From: Martyn White <Martyn.White@arun.gov.uk> **On Behalf Of** Conservation Officer
Sent: 18 February 2026 16:22
To: Planning.Responses <Planning.Responses@arun.gov.uk>
Cc: Kathryn Welch <Kathryn.Welch@arun.gov.uk>
Subject: LU/29/26/PL

LU/29/26/PL

25 River Road Littlehampton BN17 5BZ

Demolition of existing garage/offices with associated hard standing and construction of 2 No residential building comprising of 3 No one bedroom houses and 1 No two bedroom house. This application affects the character and appearance of the Littlehampton (River Road) Conservation Area and is in CIL Zone 4 and is CIL Liable as new dwellings.

DRAWING NUMBER  
2024.423.04

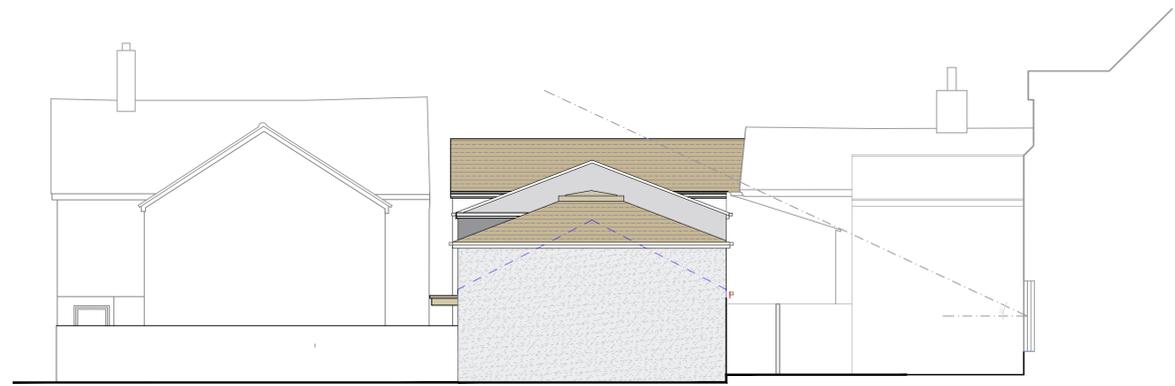
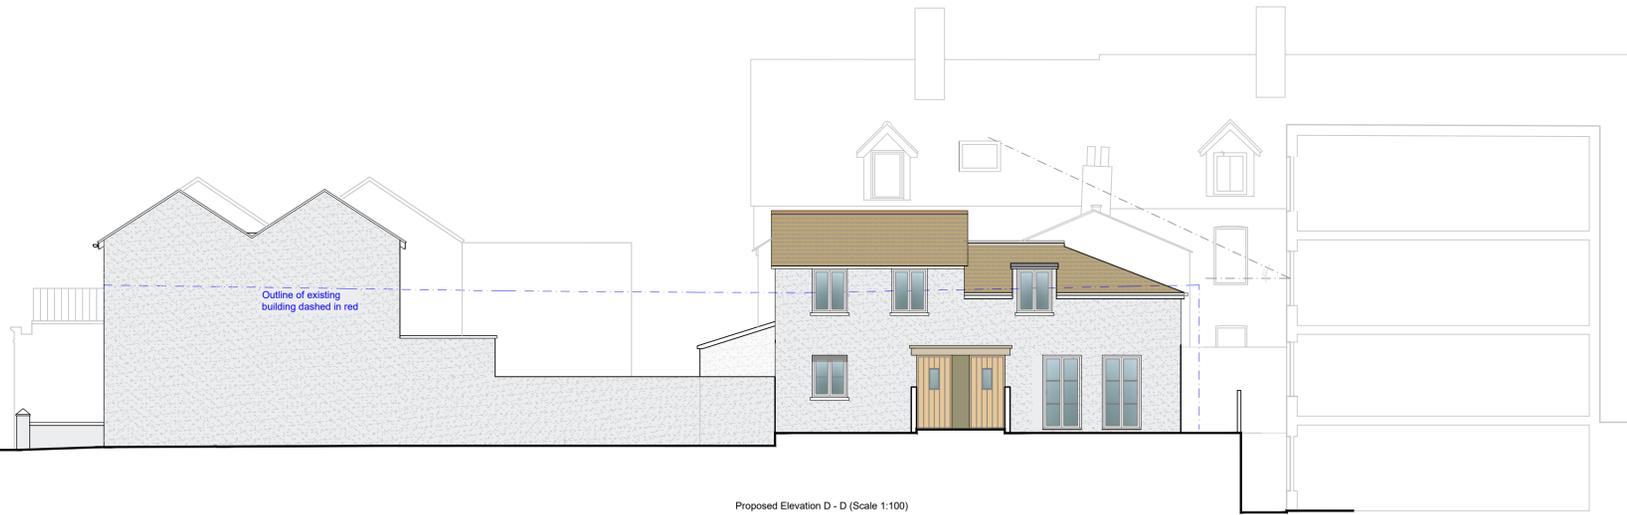
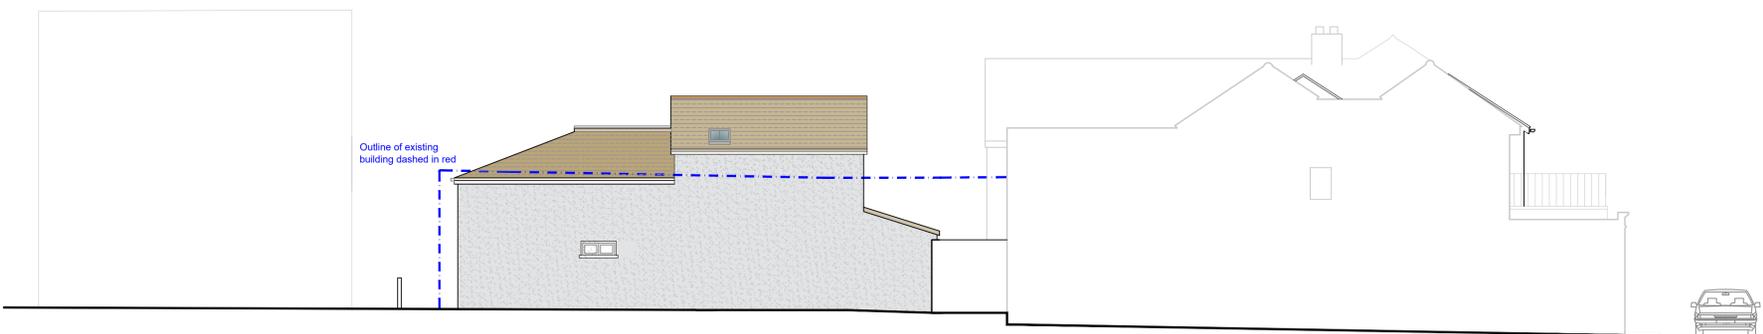
The River Road building would be two-storey with a pitched roof and parapet detailing. It is positive to note that the building reflects the characteristics of the River Road buildings in that it would have a rendered finish with timber-framed sash windows.

The Terminus Place building will be part single storey and part two-storey, and, like the River Road building, the fenestration pattern appears as a traditional design – in this case casement. When I visited the site it was clear that the properties fronting on to Terminus Place were smaller in scale than those on River Road and the design of this building attempts to reflect these qualities. This is noted in the fenestration arrangement and material palette.

The proposed use of render on both buildings is positive, as is the use of timber for the windows. The attempt to reflect the pattern of traditional fenestration is noted. However, deeper window and doorway recesses are required to align with local detailing, and doorways would benefit from simple hoods. The windows should be fully functioning sliding sashes of a design and profile appropriate for a sensitive historic location such as this. It is not clear what materials are proposed for the doors, but they should also be timber in order to preserve the character of the buildings and the wider conservation area.

Traditional roofing materials in the conservation area are natural slate and plain clay tiles, with natural slate characteristic of the late-19th- and early-20th-century buildings. Modern substitutes would be harmful and should be avoided; natural slate, which weathers positively and contributes to the area's established character, should be used instead.

Details of all materials, colours and joinery should be secured by condition should you be minded to support the application. These details should be provided through appropriately scaled drawings, including cross-sections showing the frame, glazing bars and their position within the window opening.
